211022 TAAB

**Wee Waa High School**  
**Traffic Response to Submissions**

This letter aims to respond to items raised by authorities and the public during the exhibition period for the Wee Waa High School Project (SSE-21854025).

PUBLIC DOMAINS WORKS PLAN

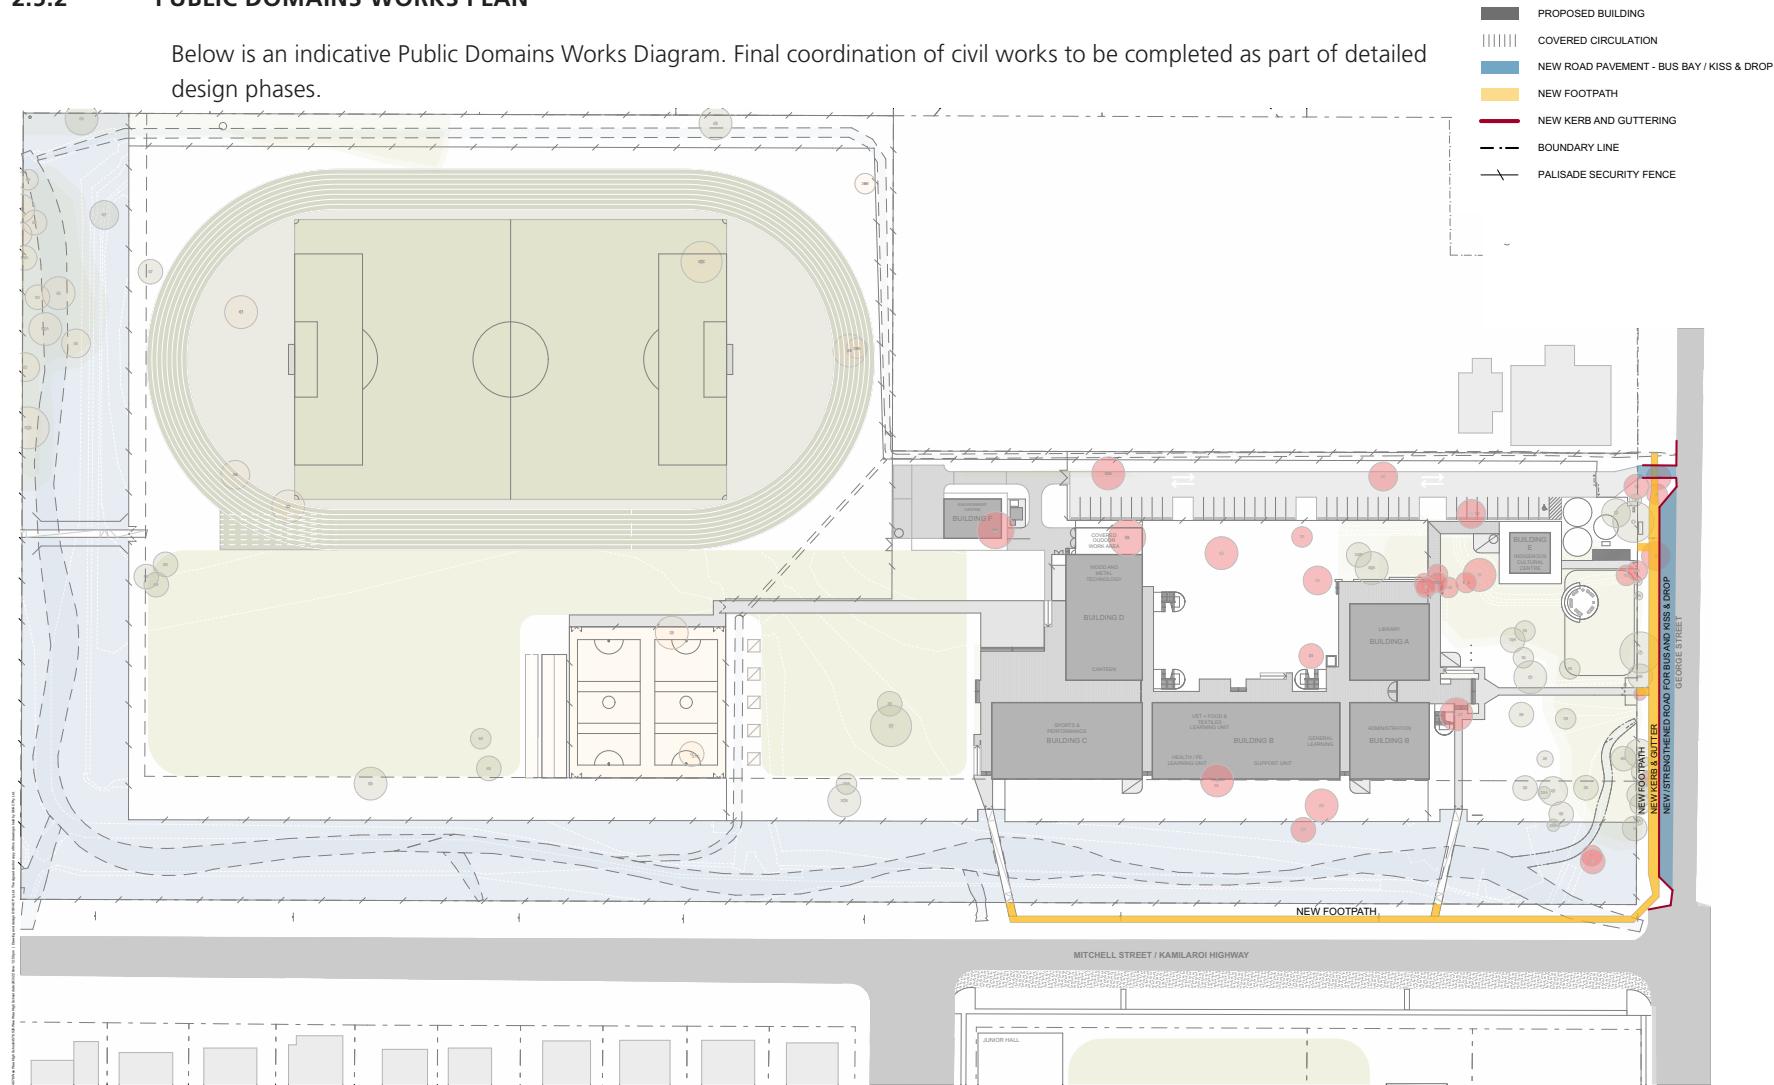
*TfNSW does not support the location of a pedestrian crossing across the Kamilaroi Highway as depicted on the submitted plans. TfNSW notes that the traffic and pedestrian numbers are not likely to meet TfNSW warrants and safety considerations for approval of a pedestrian crossing.*

*Subject to support by Narrabri Shire Council TfNSW suggests that Kerb extensions, with no pedestrian refuge, designed in accordance with TfNSW Technical Directions, Australian Standard – Manual for uniform Traffic Control Devices and Austroads Design Guide Part 4 Intersections and Crossings be installed on Mitchell Street on the western side of the Mitchell and George Streets intersection to provide a formalized crossing location.*

*Council will not accept a painted (zebra) pedestrian crossing on Mitchell Street (Kamilaroi Highway). Similar to what Council has previously constructed on the eastern side of the Mitchell/George Street intersection, a kerb extension/blister would be acceptable only.*

Current pedestrian counts show 32 and 26 pedestrians crossing the Kamilaroi Highway in the vicinity of the site between 8-9am and 2:45-3:45pm respectively. Vehicle volumes in the same period indicate 180 vehicles in the AM peak and 198 vehicles in the PM peak. While current vehicle and pedestrian counts do not meet the warrants, once a safe crossing facility is in place it is expected that pedestrian travel will increase and warrants would likely be met in both time periods. This is supported by the responses within the travel mode survey.

Further to the above, since the submission of the SSDA documentation, School Infrastructure has commissioned an independent Road Safety Audit (attached in Appendix A) to assess safety issues surrounding the Kamilaroi Highway within the vicinity of the site. The Road Safety Audit identified a high level of risk with both the distance required to cross the Kamilaroi Highway and the high percentage of heavy vehicles on the Kamilaroi Highway. The provision of a marked pedestrian crossing with kerb blisters will reduce these risks identified within the audit.

It is noted that TfNSW supports the installation of kerb extensions. While the installation of kerb extensions will increase pedestrian safety and assist in reducing the distance required to cross, it will not provide legal priority to pedestrians crossing. If warrants were not expected to be met then this would be an acceptable solution, however as noted previously, these warrants are likely to be met once. This would not achieve the aims of the Road User Space Allocation Policy as it would prioritise freight.
